From: Maria Tomalova <Maria.Tomalova@arun.gov.uk>
Sent: Wednesday, September 13, 2023 5:54 PM
To: Planning.Responses <Planning.Responses@arun.gov.uk>
Subject: FW: Y/105/19/PL and Y/106/19/L, Stakers Farm

From: Maria Tomalova
Sent: Thursday, June 18, 2020 12:59 PM
To: Ben Daines [REDACTED]
Subject: Y/105/19/PL and Y/106/19/L, Stakers Farm

Please see below Martyn's comments in red and mine in green.
(your email from 22nd May 2020)

Drawing Title
Proposed Plans - Barn 1

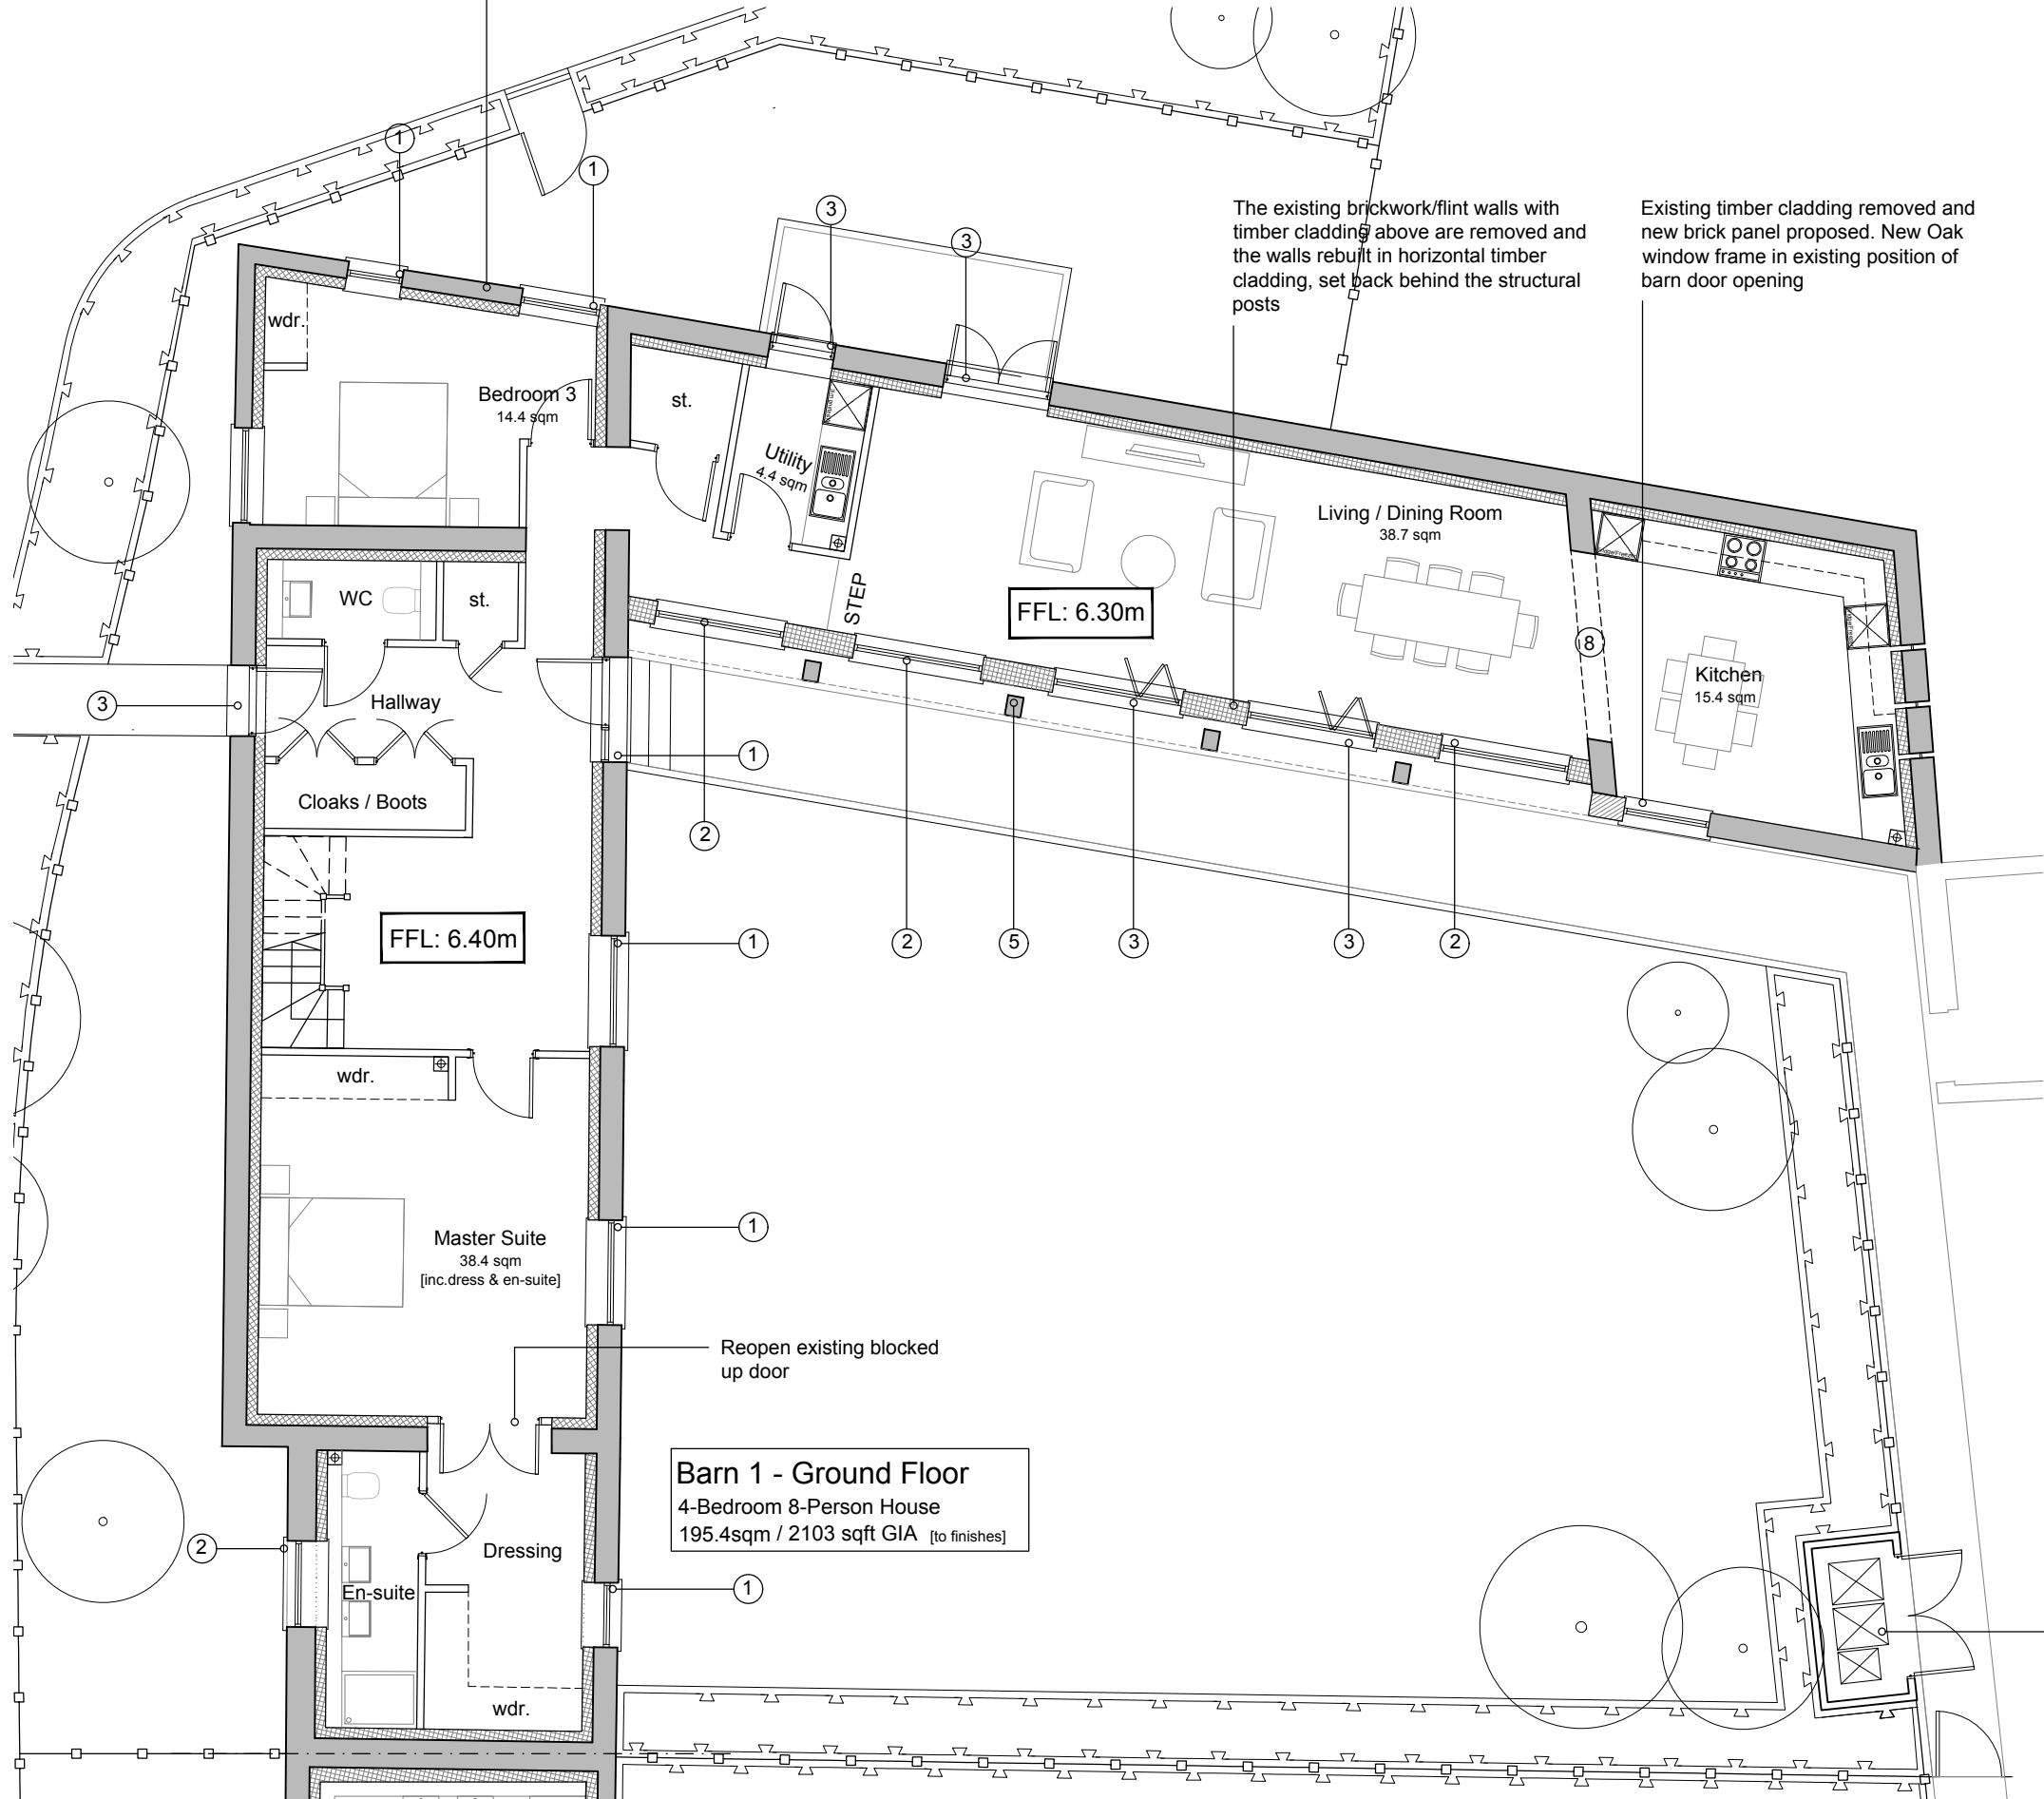
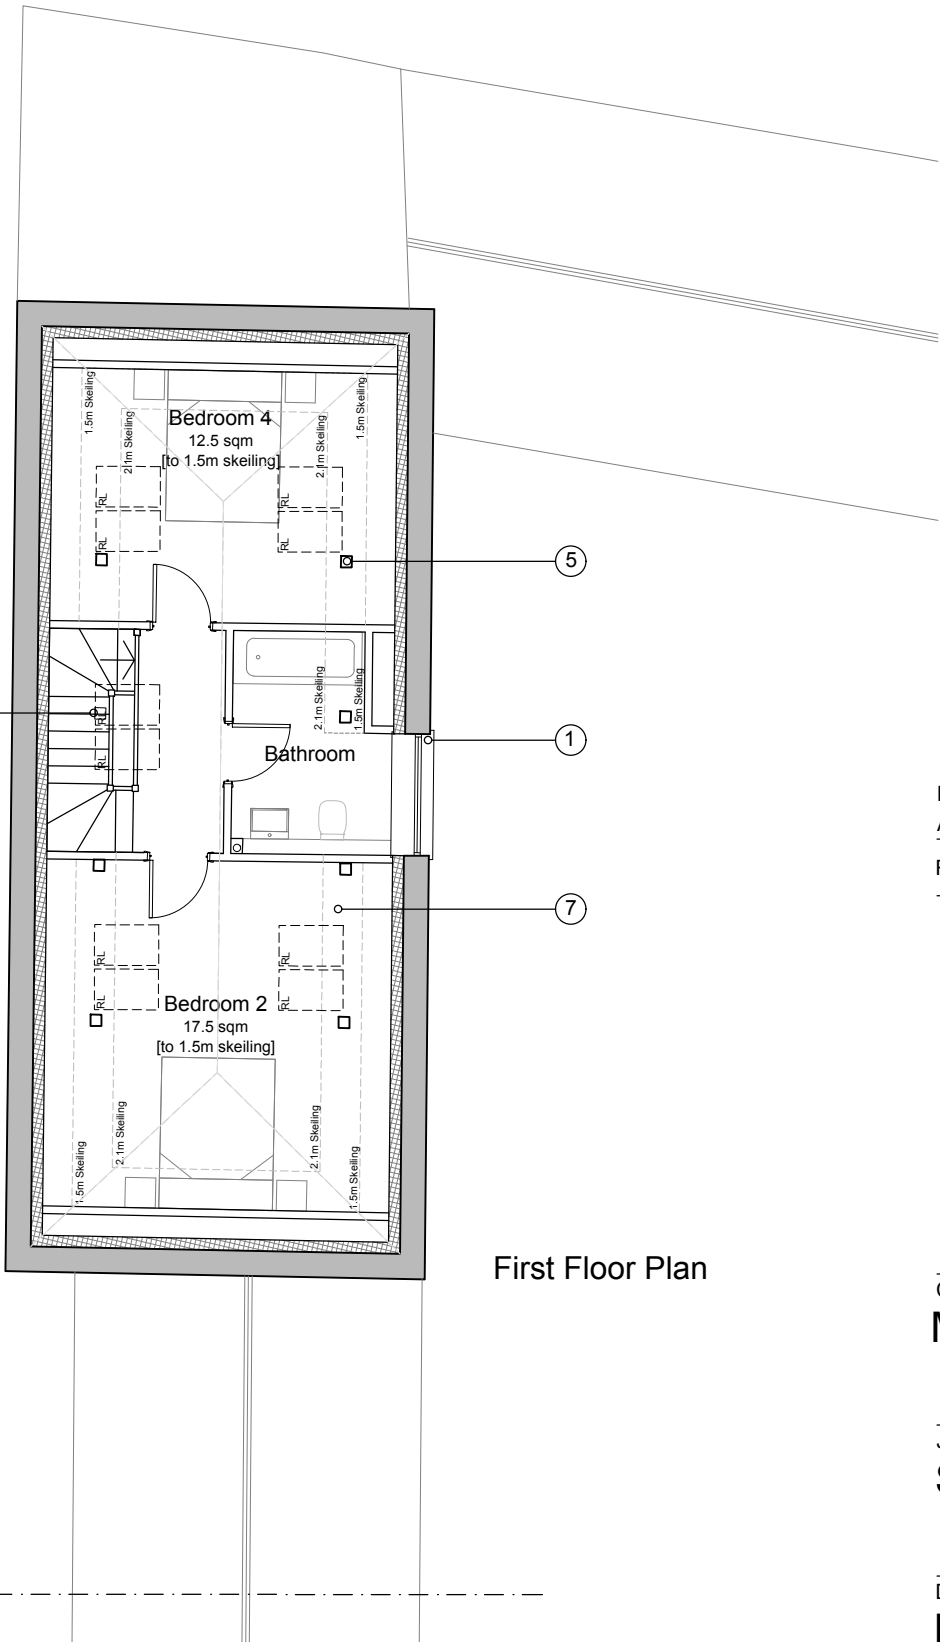
We will remove as many rooflights as possible from this barn. However, we cannot remove all the rooflights as we will need to provide light to the bedroom to make it a habitable space. A roof light will also be required to provide purge ventilation (Part F of Building Regs) otherwise a mechanical system would be needed. Under the Building Regulations we will also need to meet the Daylight and room brightness guidance set within British Standard BS 8206-2:2008 Lighting for Buildings. We will therefore seek to provide the very minimum amount of rooflights necessary to meet Building Regulations and seek to locate them on the least prominent part of the roof.

There should be as few rooflights as possible, and these should be placed on the rear elevations where they will not be visible. They should also be of conservation standard. No roof-lights on primary elevation. A casual glance should not reveal that the building has been converted. This means that unconventional arrangements of rooms are required. Roof structures comprise a dominant visual feature and should be left uninterrupted.

It is not clear how the interior of the barn will be treated, bearing in mind the comments I previously made regarding the interior. This needs careful consideration and more information to be supplied to us
